From: Holly Myers
Sent: Wednesday, December 16, 2015 4:14 PM
To: Jeff Watson
Cc: 'Ross Anderson (rossa@acarchitect.com)'
Subject: RE: BL-15-00016 Anderson PH Comment

With regard to the Anderson Boundary Line Adjustment; Public Health approves the boundary line adjustment with the following conditions:

ANDERSON PROPERTY

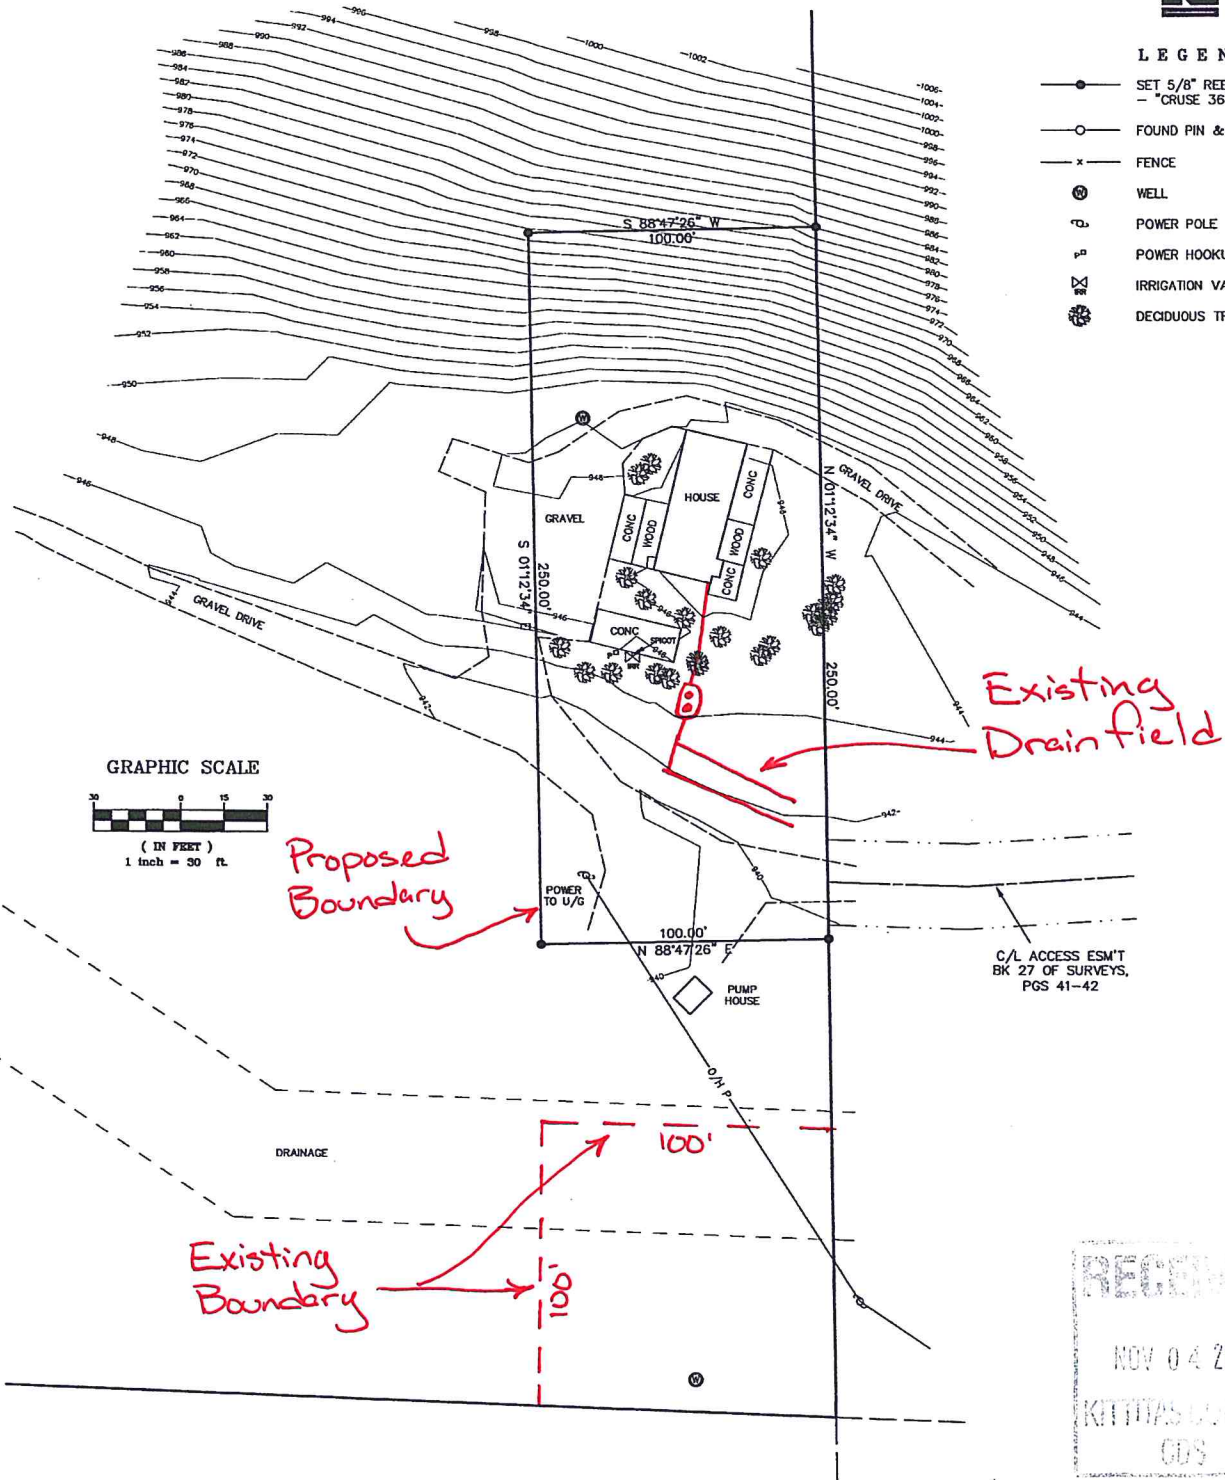
1. Applicant must show the drain field of the current system meets setback requirement of 10 feet from the proposed boundary line; and
2. Applicant must submit a recorded shared well users agreement for the well that is intended to serve both parcels. Applicant must present a copy of the recorded shared well users agreement to Public Health through email at holly.myers@co.kittitas.wa.us or deliver to the office at 507 Nanum St. Ste 102, Ellensburg WA 98926
